Application reference; 20/03665/PLF

We wish the following to be well considered against the proposed new build plans on the plot situated North of 13 Hazel Avenue, Withernsea.

**FRONT EAST ELEVATION**  
PROPOSED - SCALE 1:50

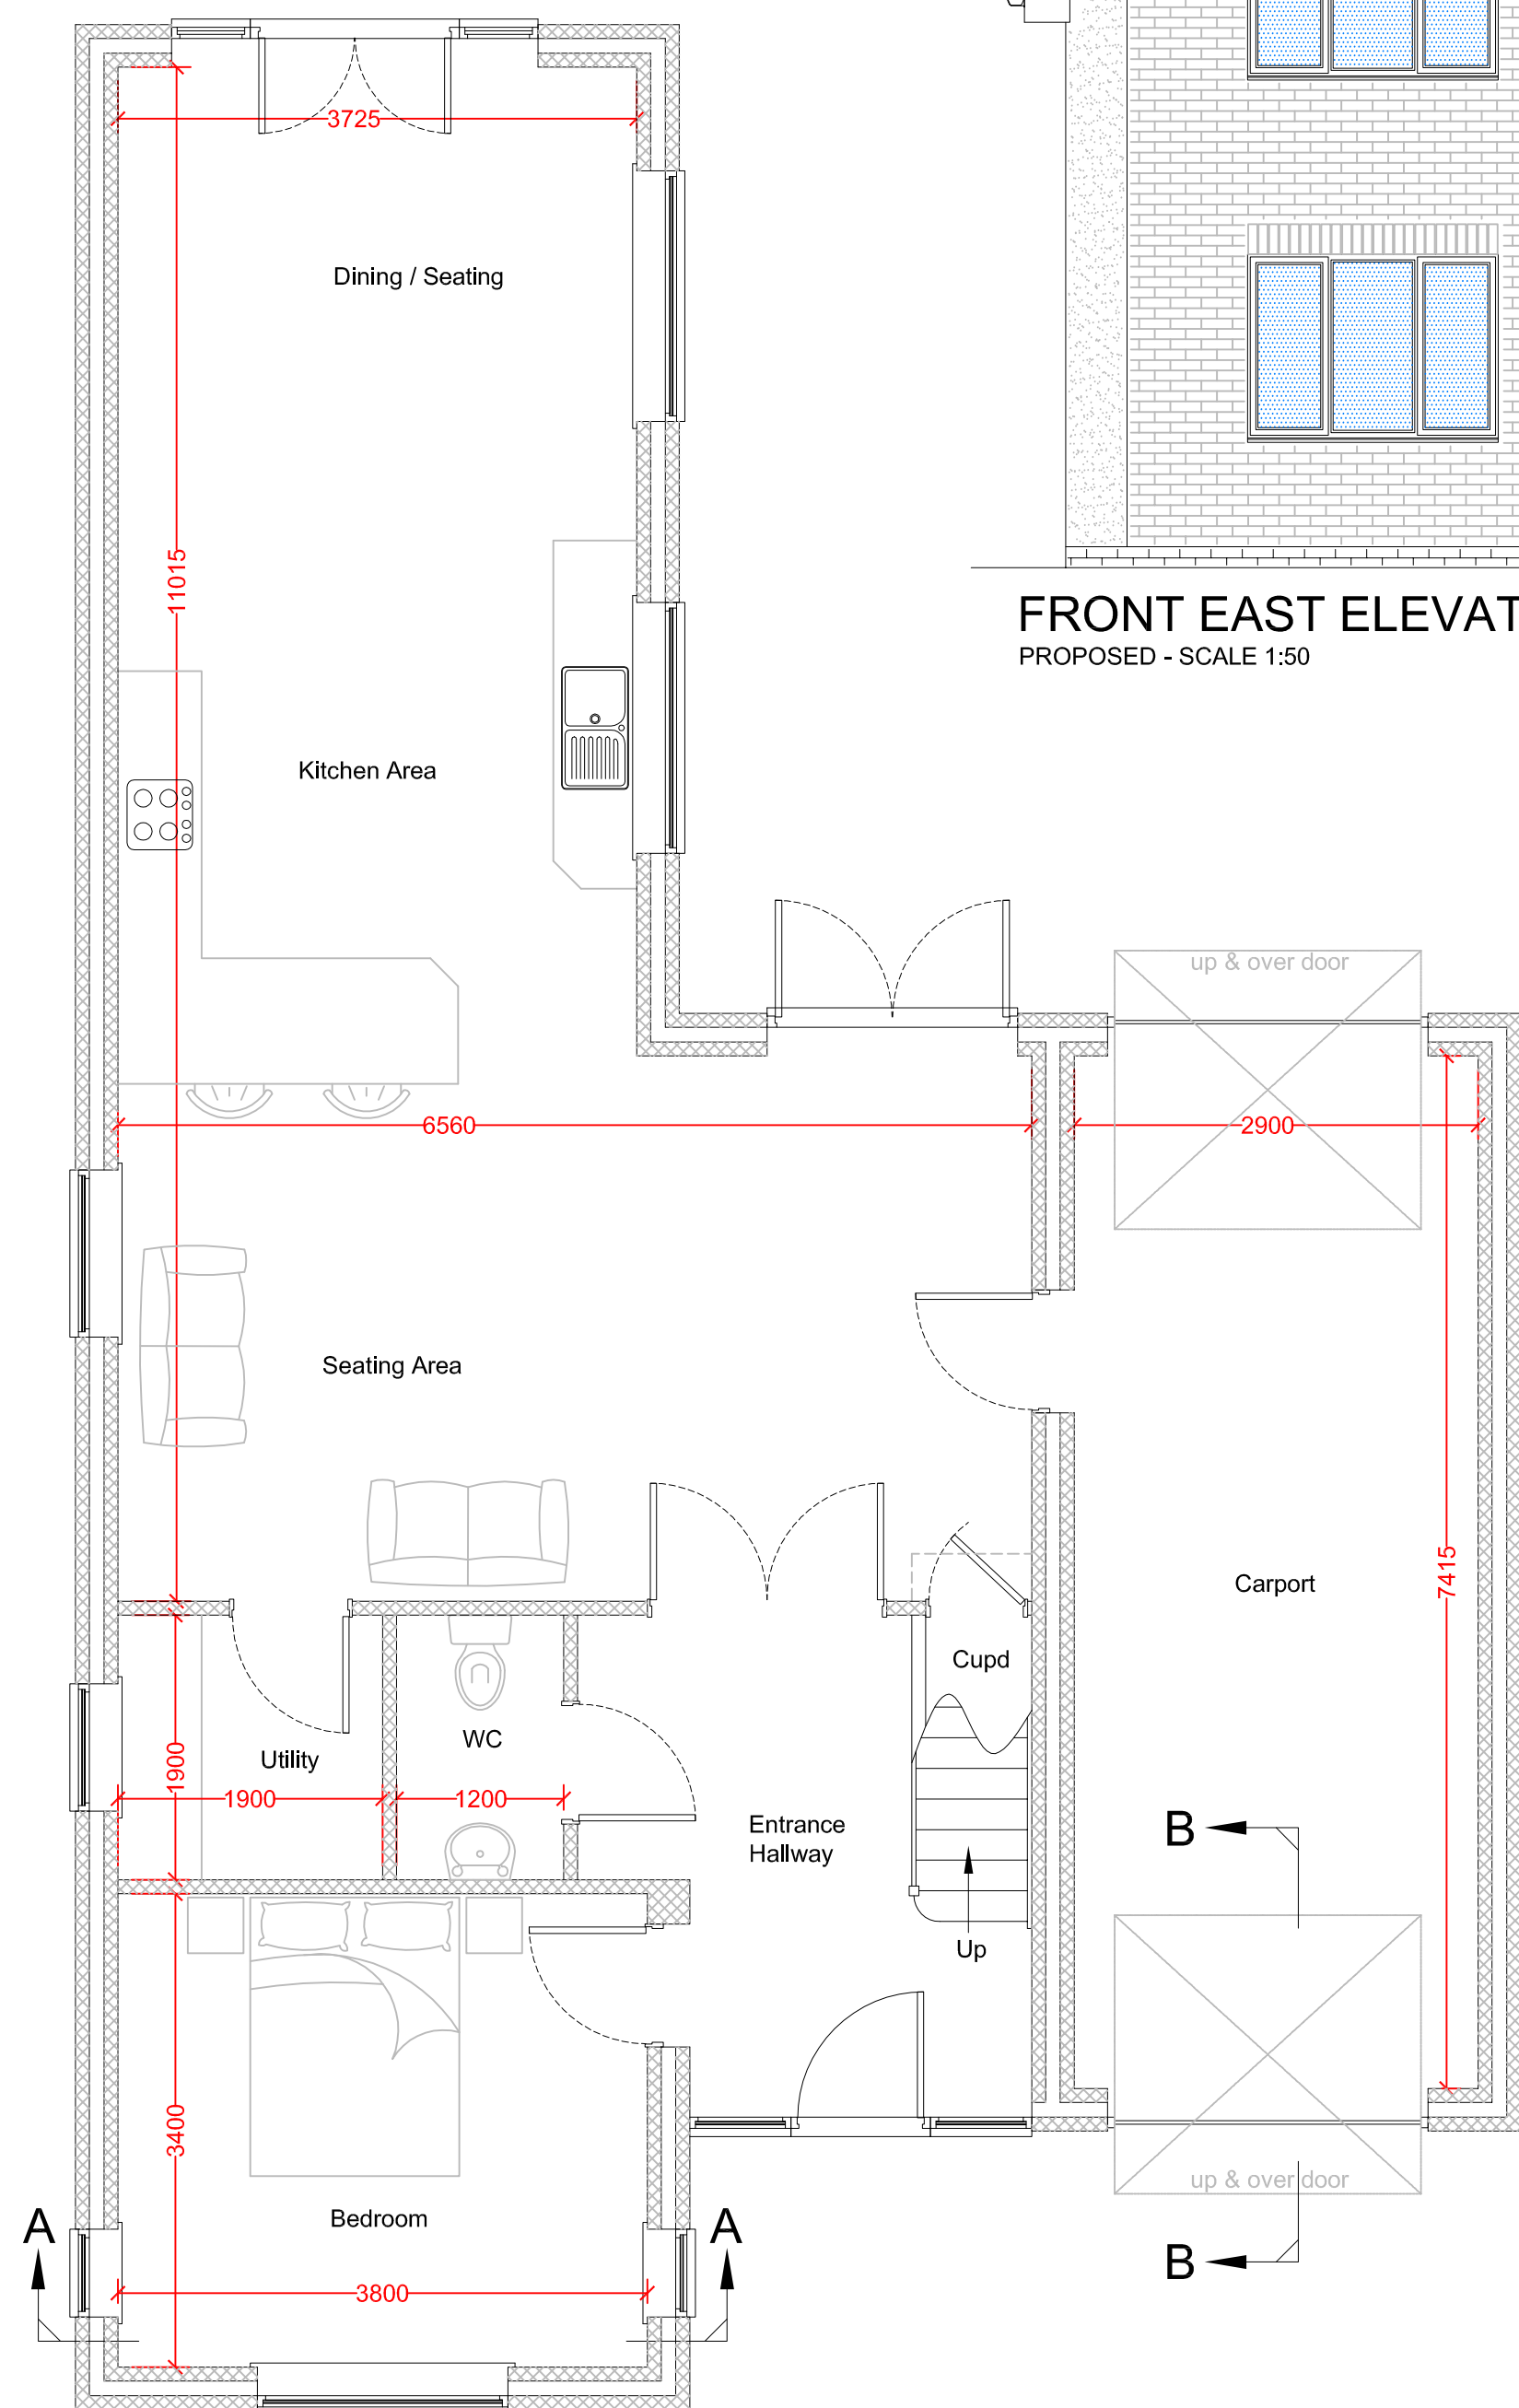
We take issue with the intended upper floor window, front face, bedroom above bedroom. There are hardly any upper floor windows to the neighbouring properties. The **only** one currently with a possible view into our property is side on at number 11 and has no impact on our privacy as it is also screened by their tree.

This upper floor window would give an extremely good view, down, widely inside, all our front main rooms, as well as invading the privacy of our main garden seating area, which we like to use a lot, as a peaceful private spot.

Serious consideration should be given to alleviating this anticipated, unwanted, privacy invasion of our normally private family life. From this window so much of it would be able to be viewed. I cannot think of any alternative other than changing this window somehow. Keeping my curtains shut during daytime is not a reasonable option and is not a solution for the garden. A fully grown hedge height would not deal with this overlook either.

SITE PLAN
PROPOSED - SCALE 1:200

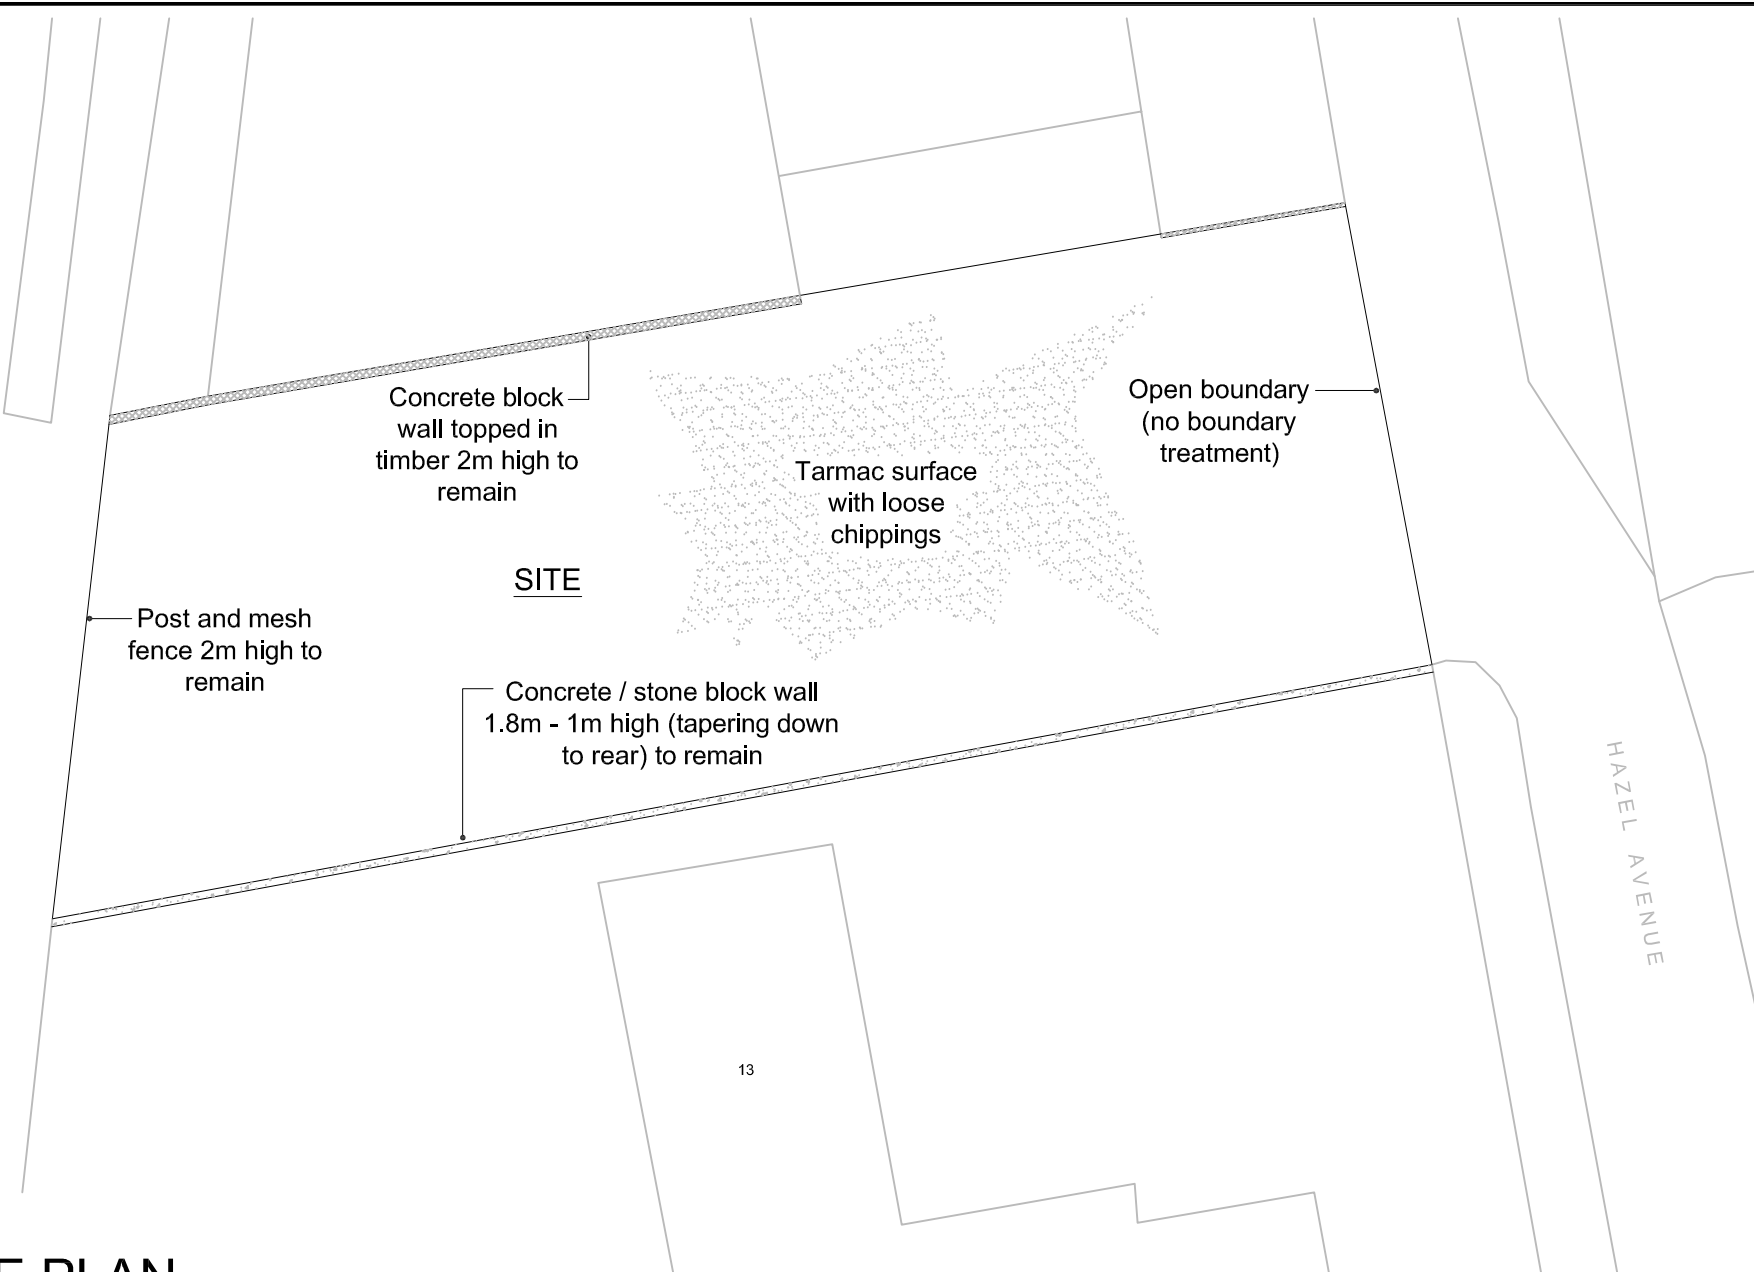
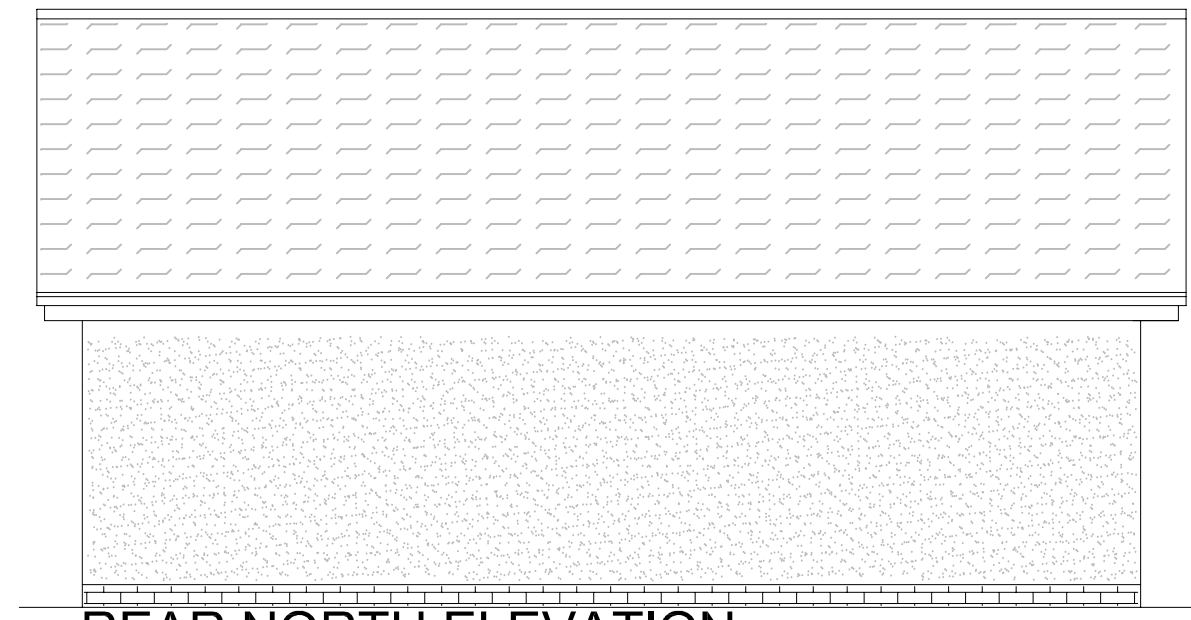
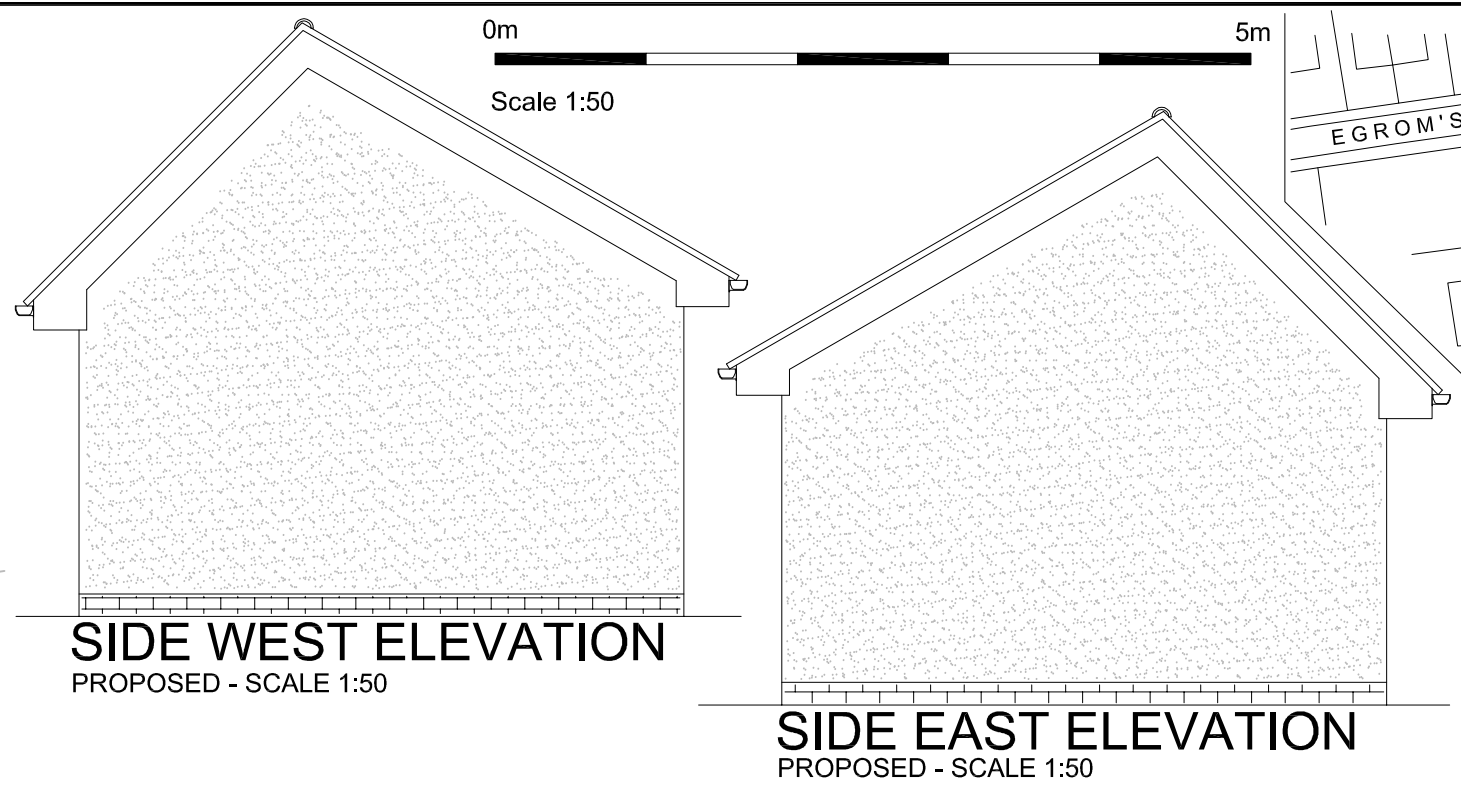
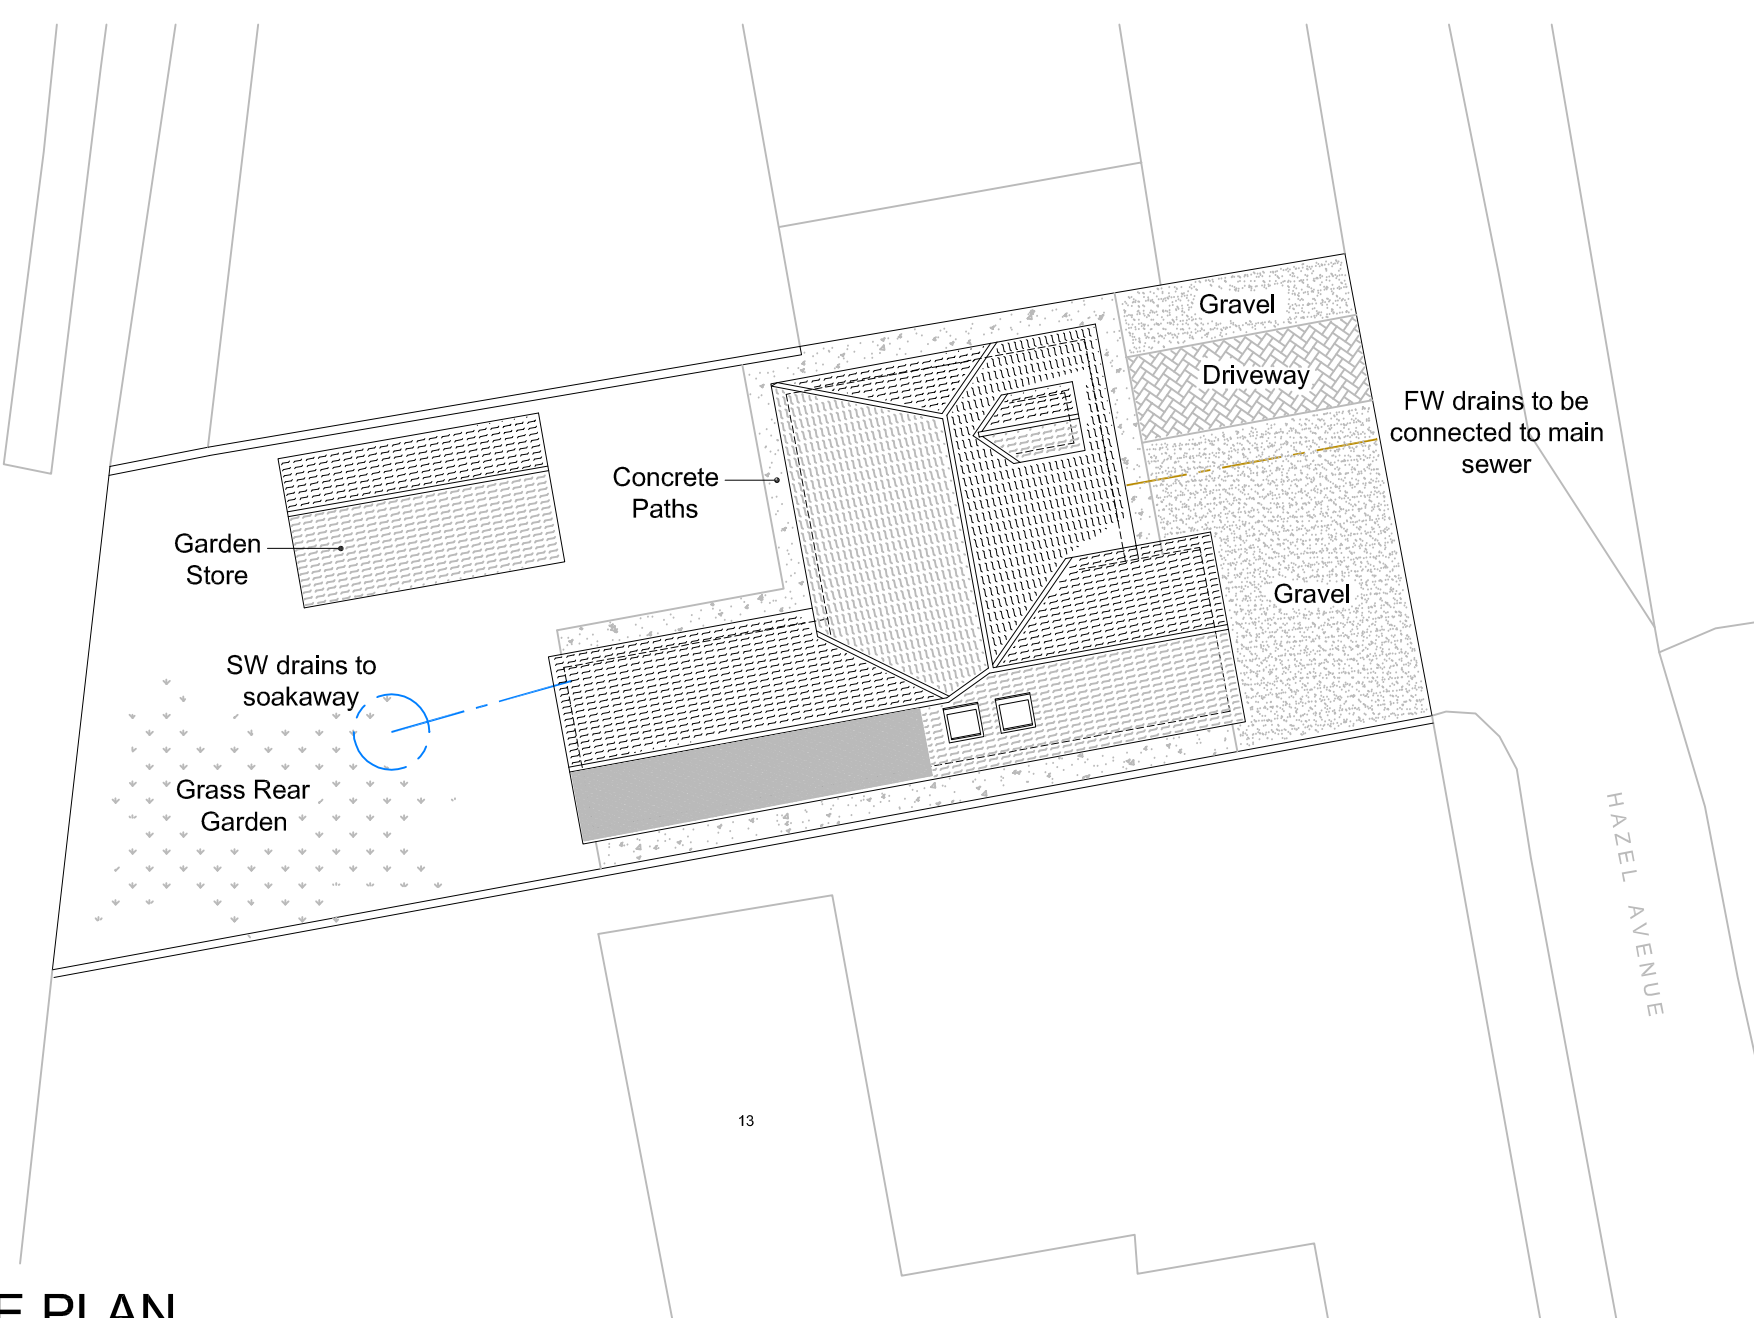
The plans are a little unclear on where/how the 4 cars mentioned would park. It is imperative to provide a layout that holds all cars invitingly, to best avoid temptation of adding to the only just manageable overspill problem along Hazel avenue as it is. Don't forget this is not simply adding one rather large capacity property, but also the loss of the car park which the Golf Club hadn't minded us using. The idea of the capacity of a 4 double bedroomed plan, even with intended parking for 4 cars, leaves us thinking how could we possibly not be faced with an unbearable situation with vehicles on Hazel Avenue, and was not the smaller capacity, or situation we had hoped for.

Situated at the front of the build is planned to be a gravel and single drive area. Whilst this might look nice, might it also look confusing to visitors as to whether this is gravel garden or parking area? If indeed, this is intended for the use of parking. Parking was previously defined as a clear plan for 2 cars in the south east corner, in a sensible drive in, drive out, side by side format. We know the numbers of car spaces claims to have increased, but don't seem to have been given clarification of the intended plan now.
